WEST SUSSEX COUNTY COUNCIL CONSULTATION

TO:	Arun District Council FAO: Michael Eastham
FROM:	WSCC - Highway Authority: Tim Townsend
DATE:	29 October 2020
LOCATION:	Land south of Ford Lane East of North End Road Yapton BN18 0DS
SUBJECT:	Y/105/20/DOC Approval of details reserved by condition imposed under Y/80/16/OUT relating to condition 10- Construction Method Statement. More information received.
DATE OF SITE VISIT:	19 October 2020
RECOMMENDATION:	More Information Required
S106 CONTRIBUTION TOTAL:	n/a / £ See below for breakdown.

This is the second WSCC County Highway Authority (CHA) response to the above planning application for approval of details reserved by condition imposed under Y/80/16/OUT relating to condition 10 - Construction Method Statement (CMP). Previous CHA comments were made in response dated 19th October 2020.

Scale 1:200 @A1	Date AUG 20	Designed
Drawn JA	Checked SG	Approved LH
Job No 18-344	Drawing No 18-344/703	Rev B

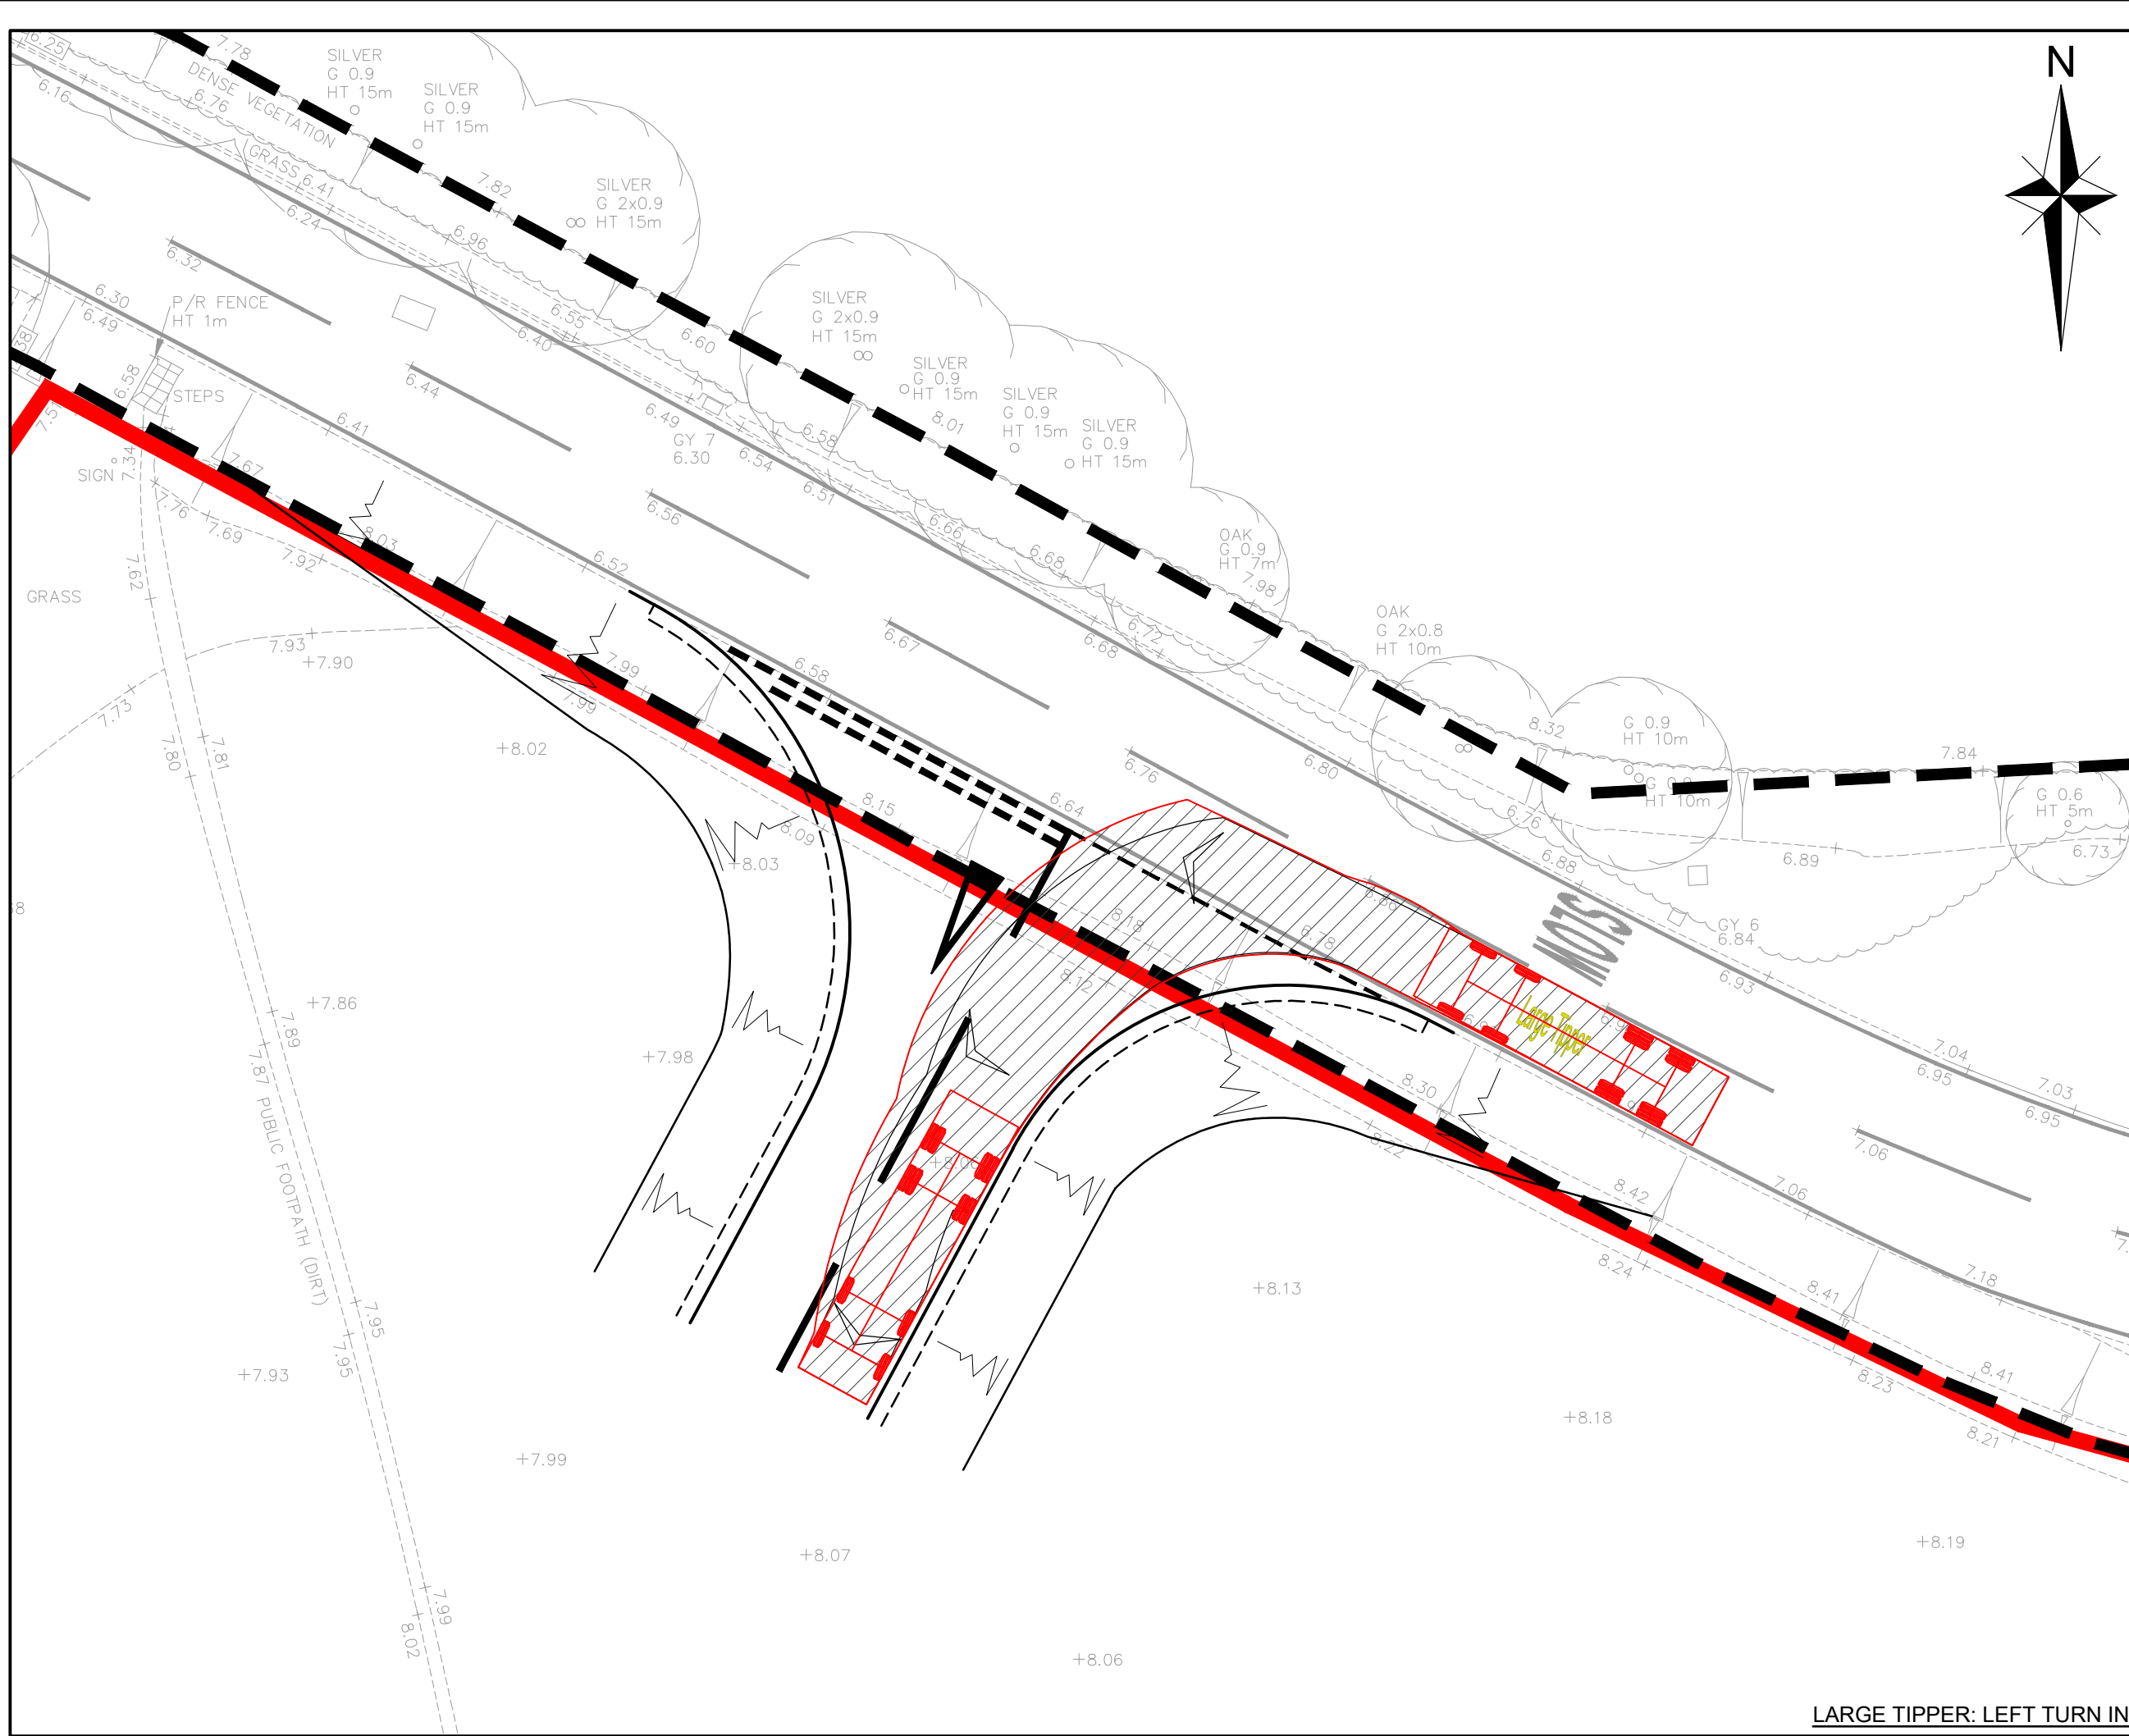
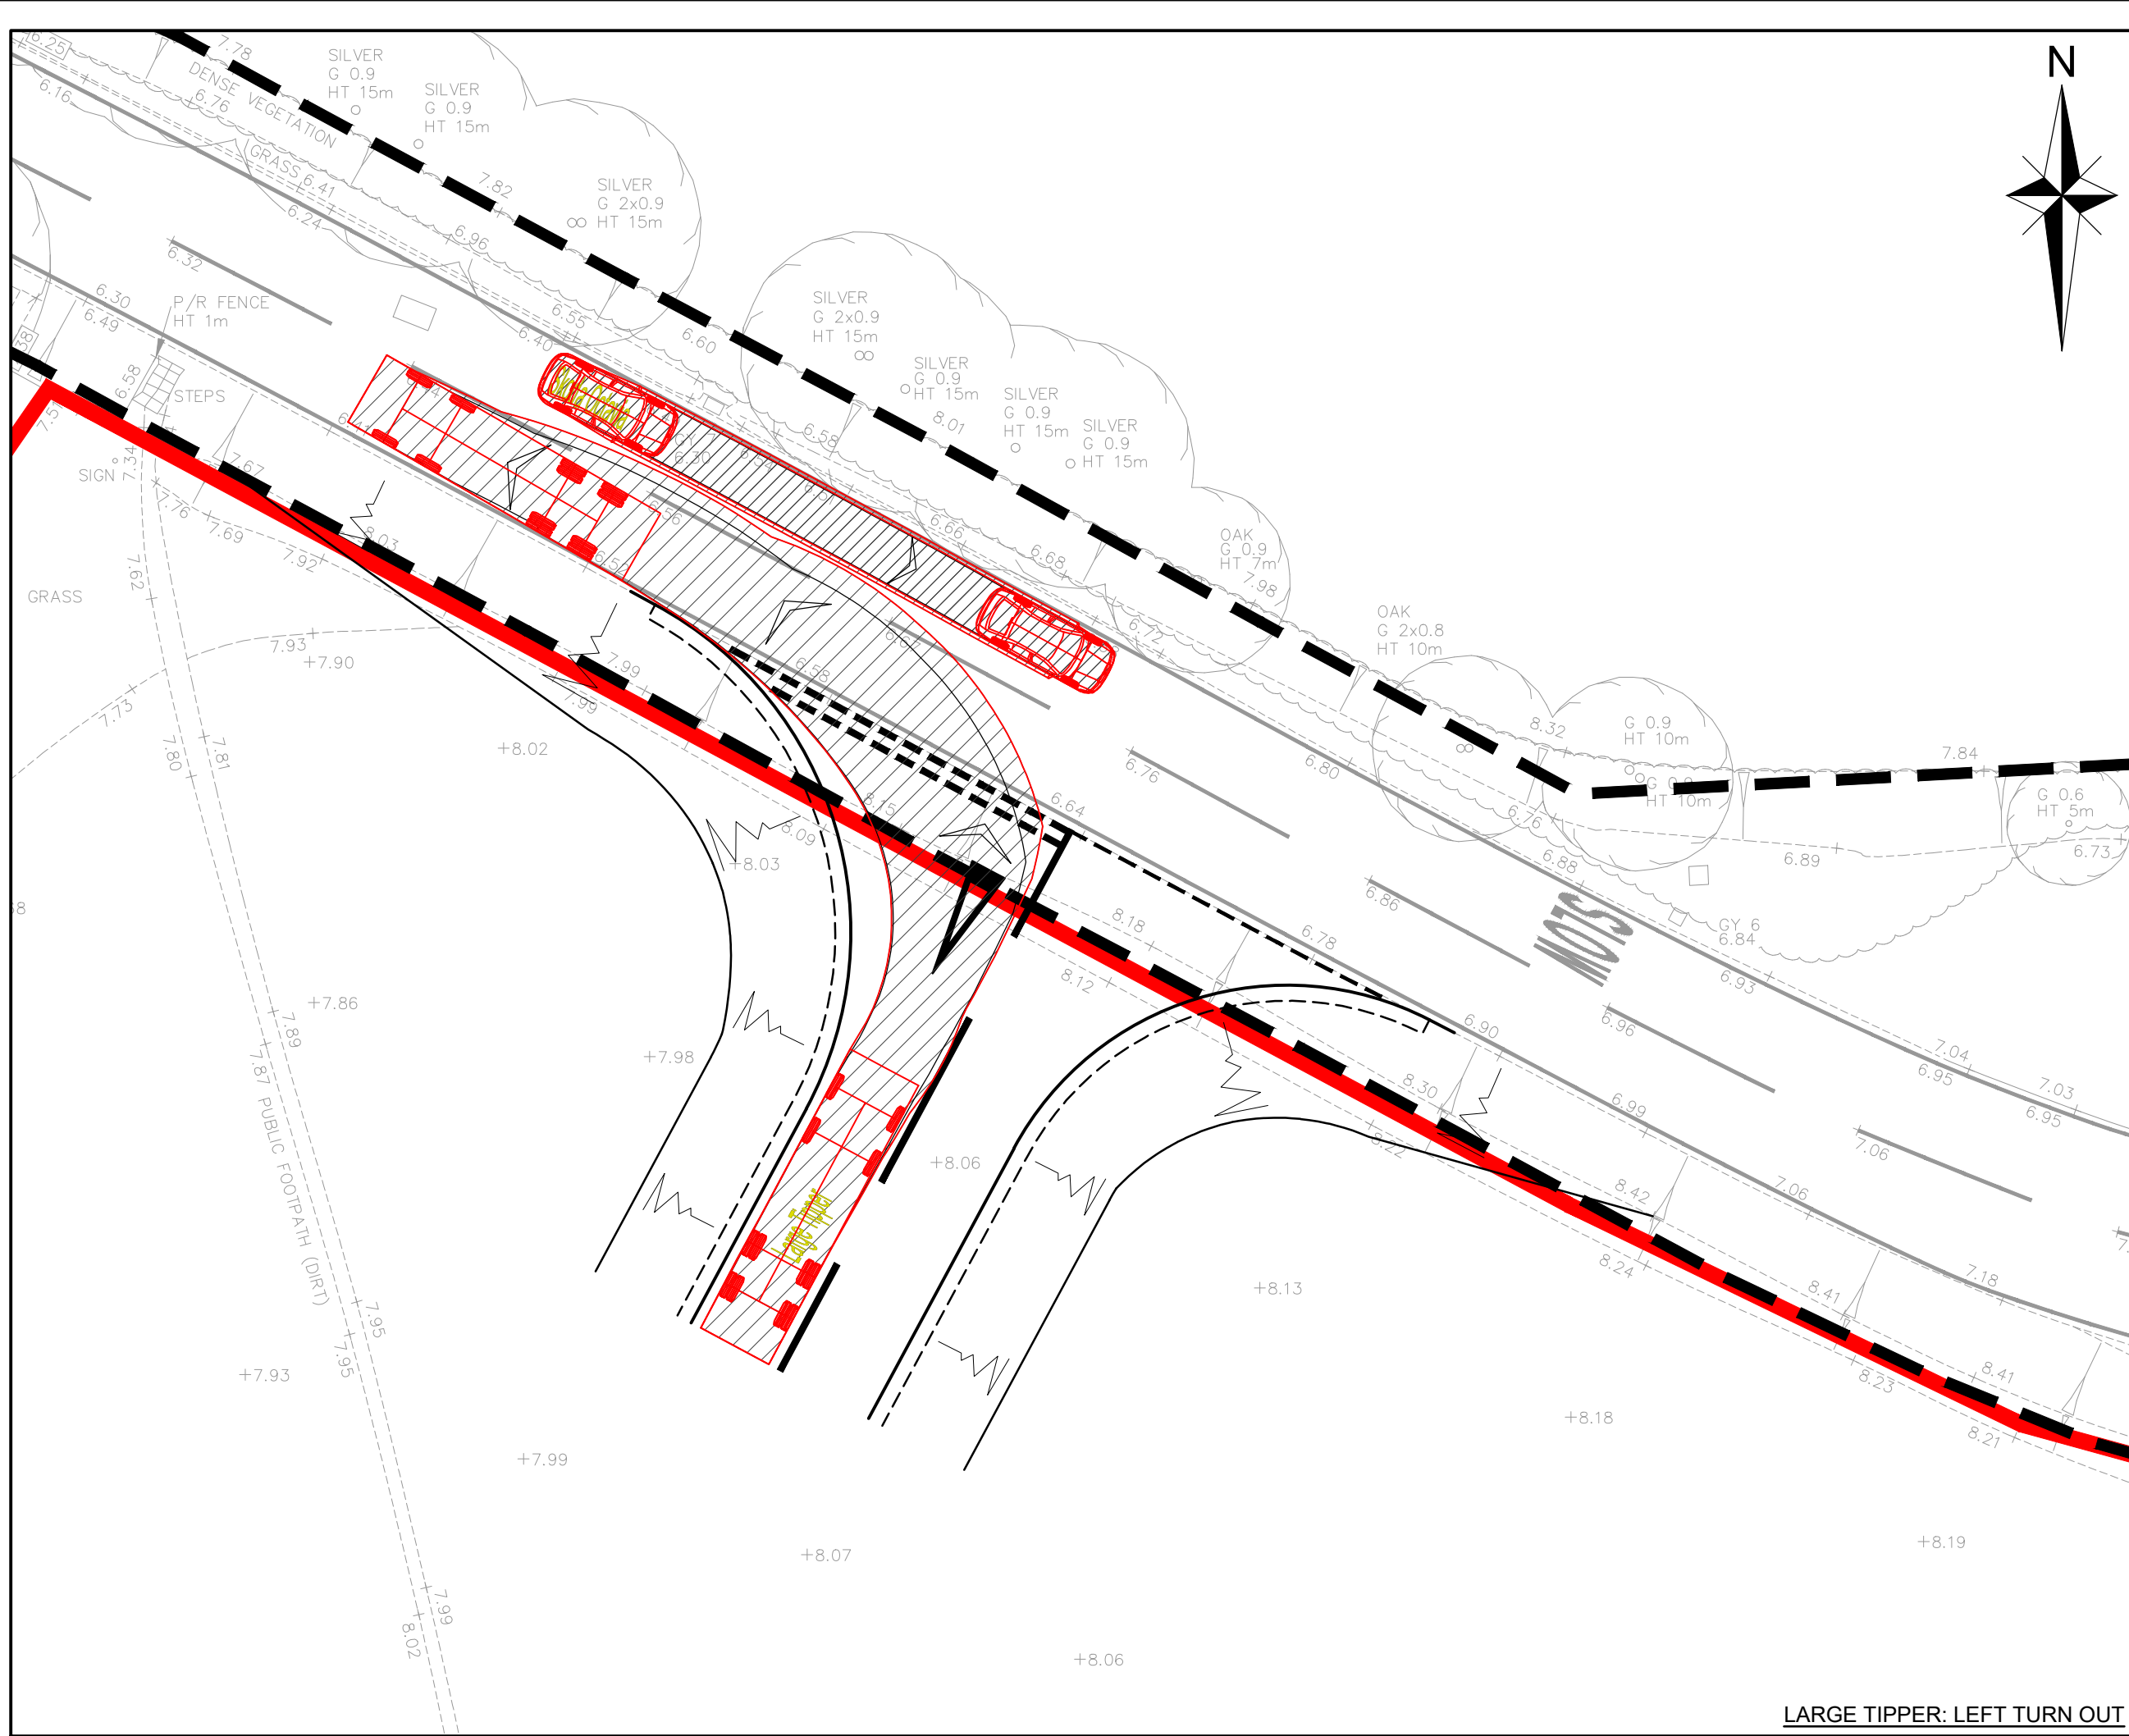
by the CHA. The designer should provide information to satisfy the recommendation contained in the Audit. If the recommendation cannot be achieved, then the designer should provide an alternative solution including information such as additional swept path diagrams, frequency of trips using the access and any other controls relating to the use of the access that would be implemented throughout the construction period.
